Application for removal or variation of a condition following grant of planning permission.  
Town and Country Planning Act 1990.  
Planning (Listed Buildings and Conservation Areas) Act 1990

House name: MEADOWVIEW

Demolition of an existing 3 bedroom house and construction of a new 3 bedroom house; separate existing double garage to be retained and upgraded with new cladding; separate existing open carport to be retained and upgraded with new pitched tiled roof.

Reference number: 19/11356 Date of decision (DD/MM/YYYY): 07/04/2020 (date must be pre-application submission)

ISSUE	DATE	REVISION	PROJECT #
PROJECT	Meadowview		
CLIENT	Helen Richards	DATE # 7 July 2022	DWG #
DWG	Proposed House Elevations	SCALE @ A2 1:100	004
		DRAWN BY	REVISED BY
		CHECKED BY	REVISION

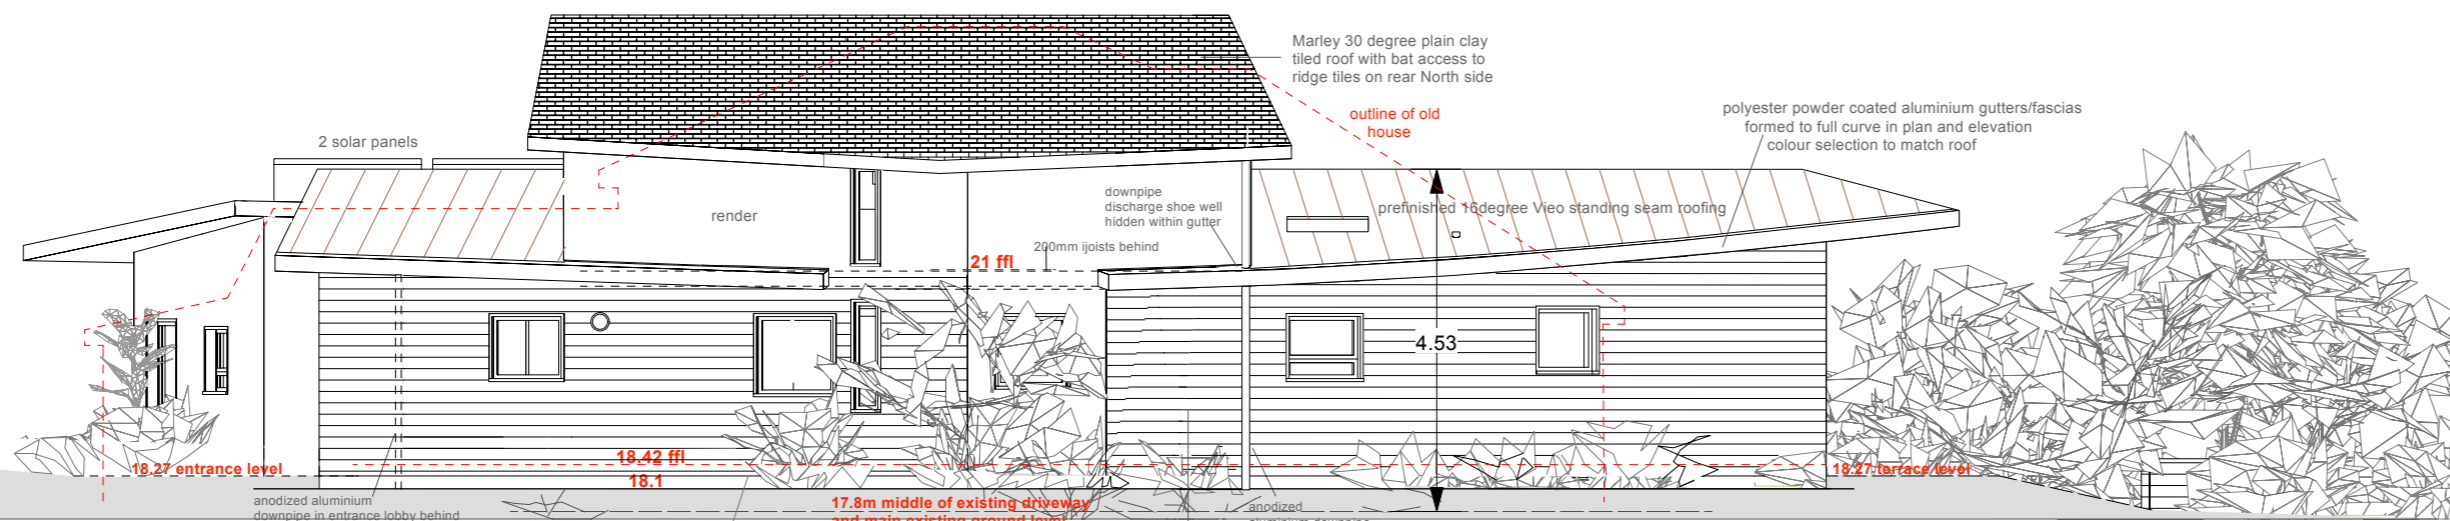
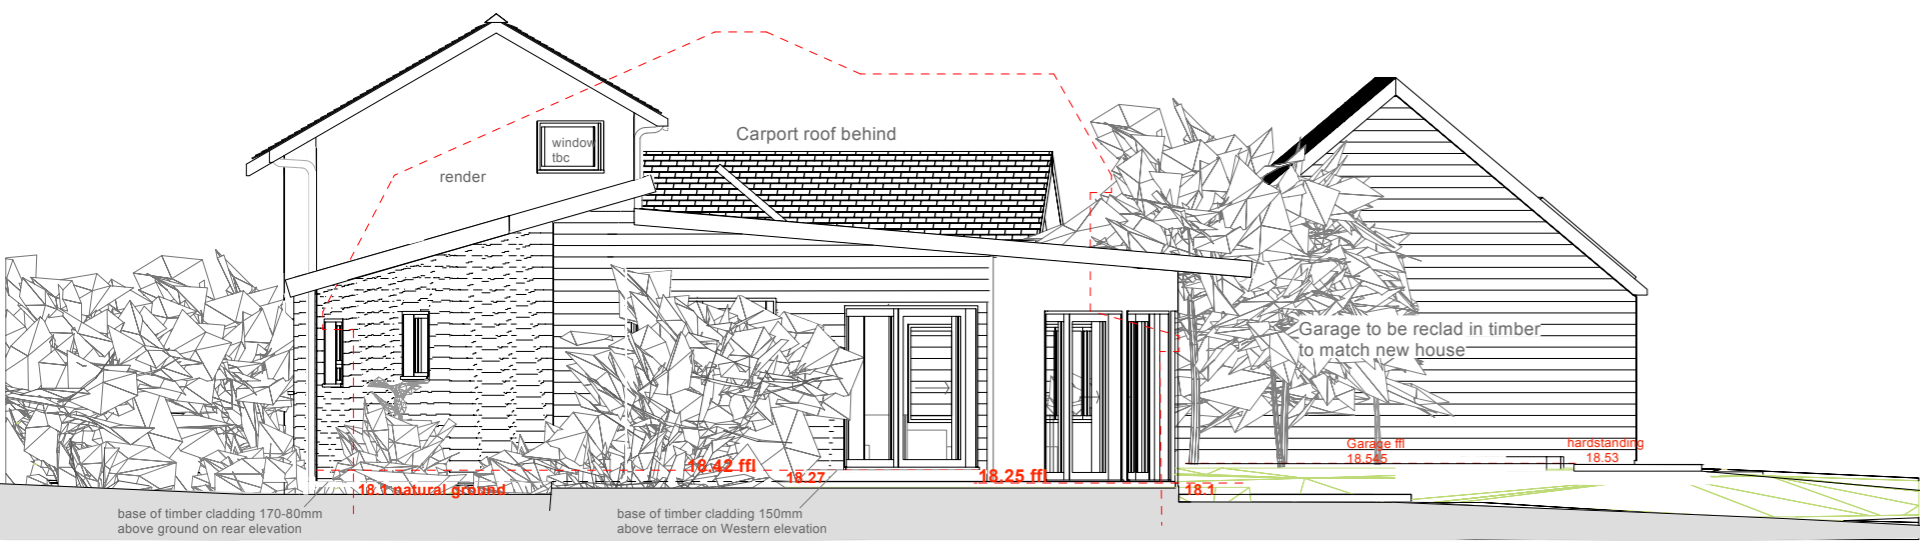
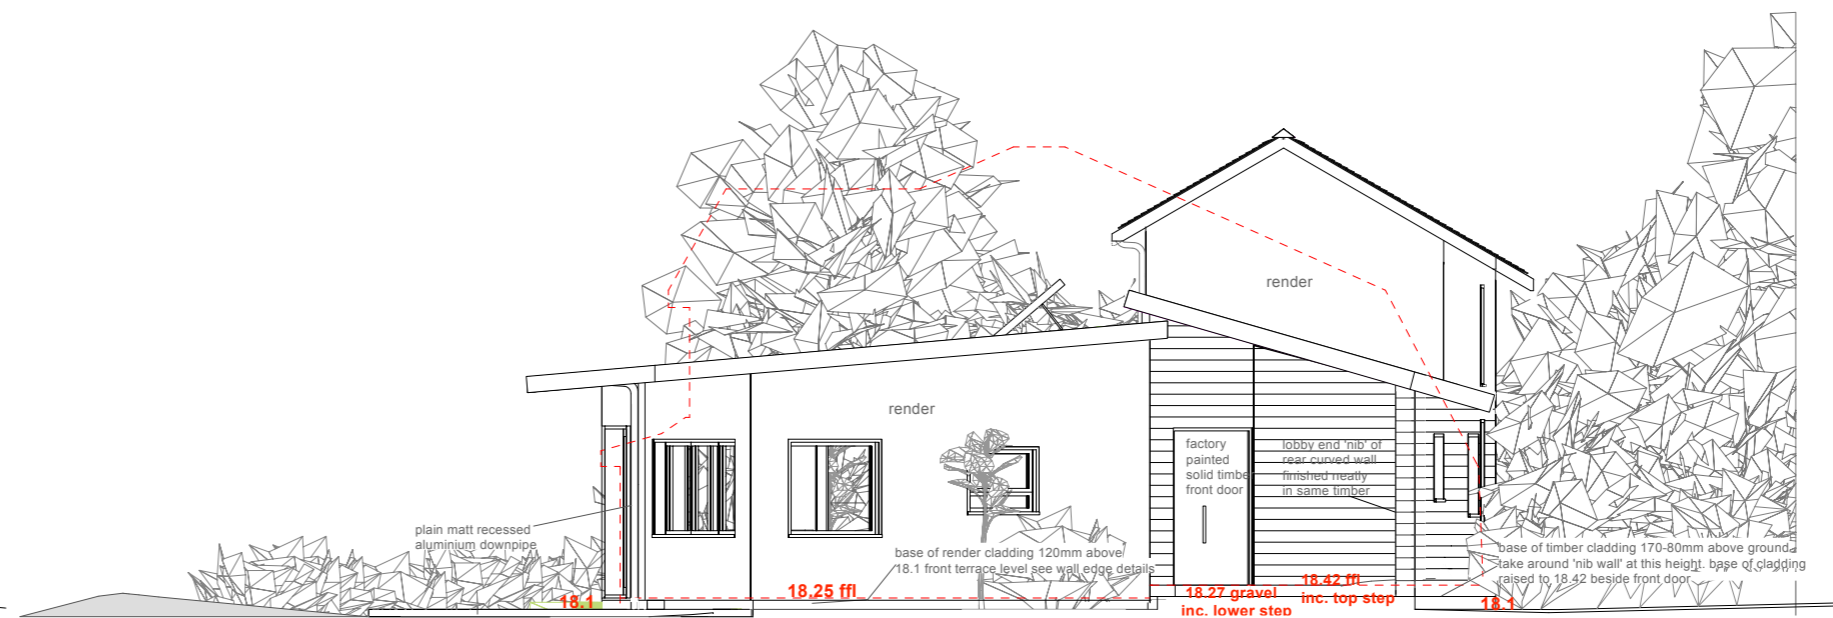
I requested the house be moved by 800mm on E/W May 22 to allow a little more space on the private boundary side. I have also requested the top ridge height be increased by 240mm following detailed design of bat chambers in ridge and min 30° clay tile roof pitch.

(in regards top ridge height increase by 240mm).

| ISSUE      | DATE                 | REVISION | PROJECT # |
|------------|----------------------|----------|-----------|
| DWG        | Proposed Site Plan   |          |           |

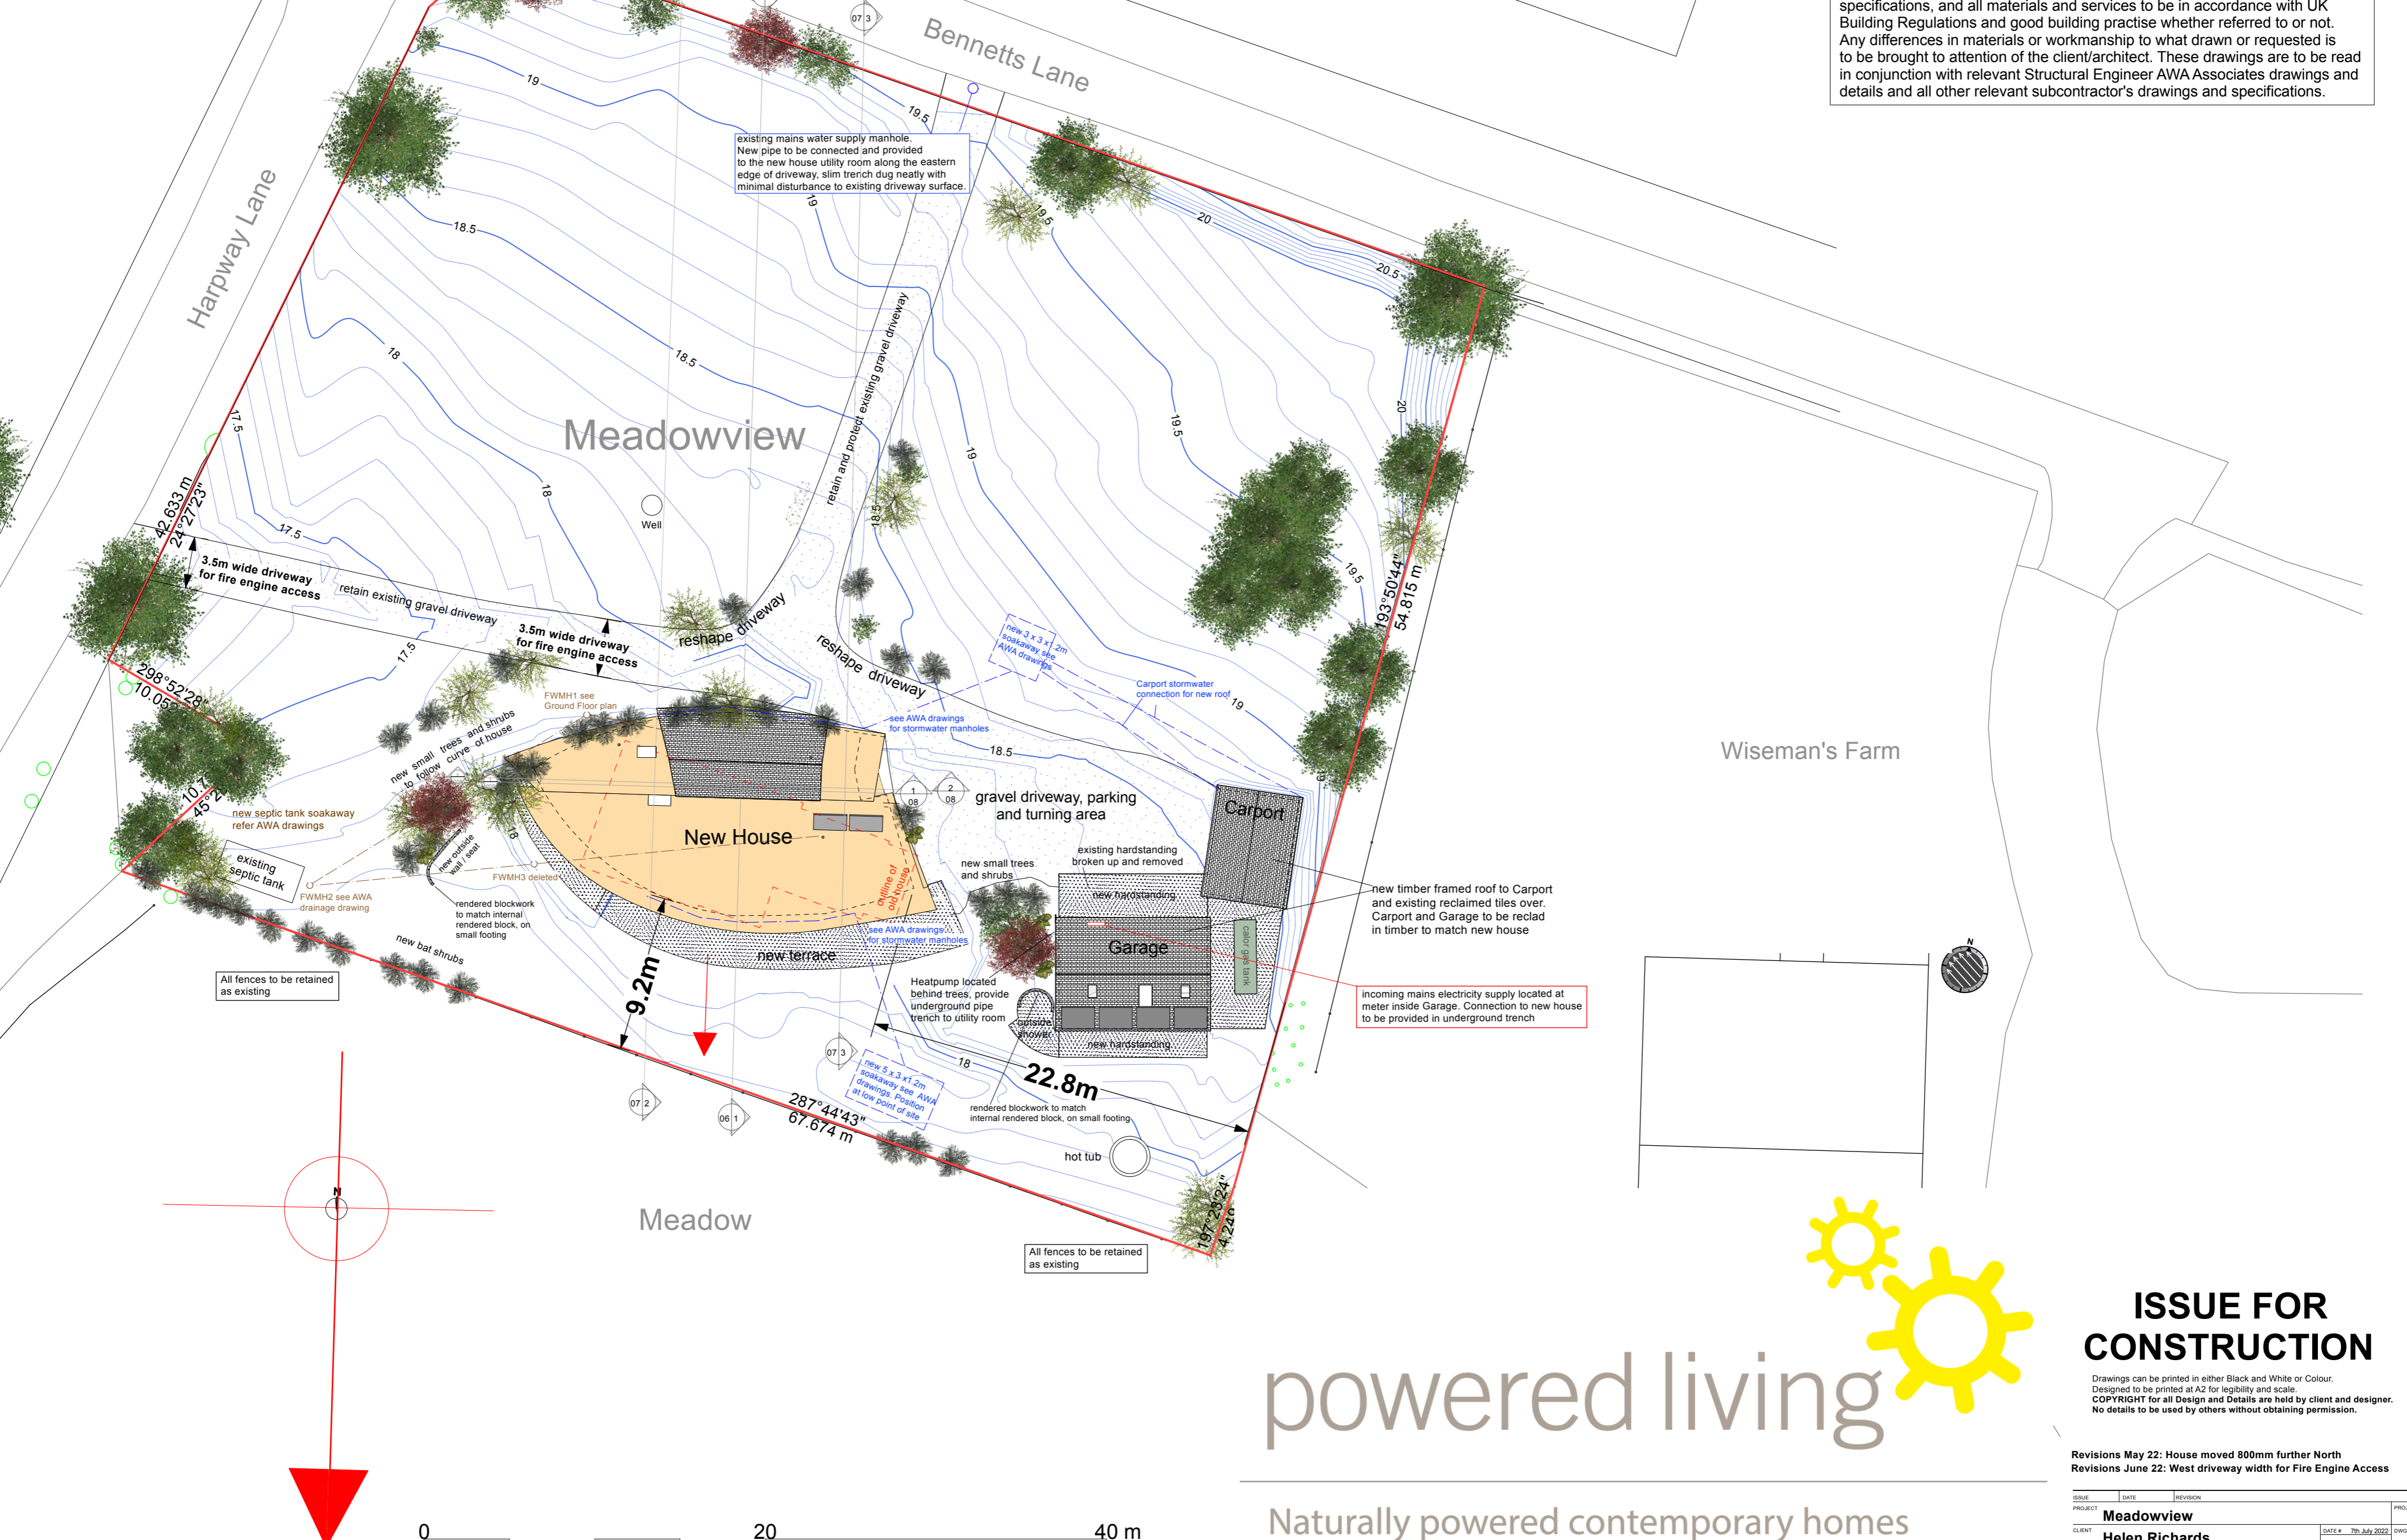
All conditions remain as currently written / described with particular attention to 001 site plan (in regards moving house by 800mm) and ~~then cross section 006, Top Roof details 007 and Elevation 004~~
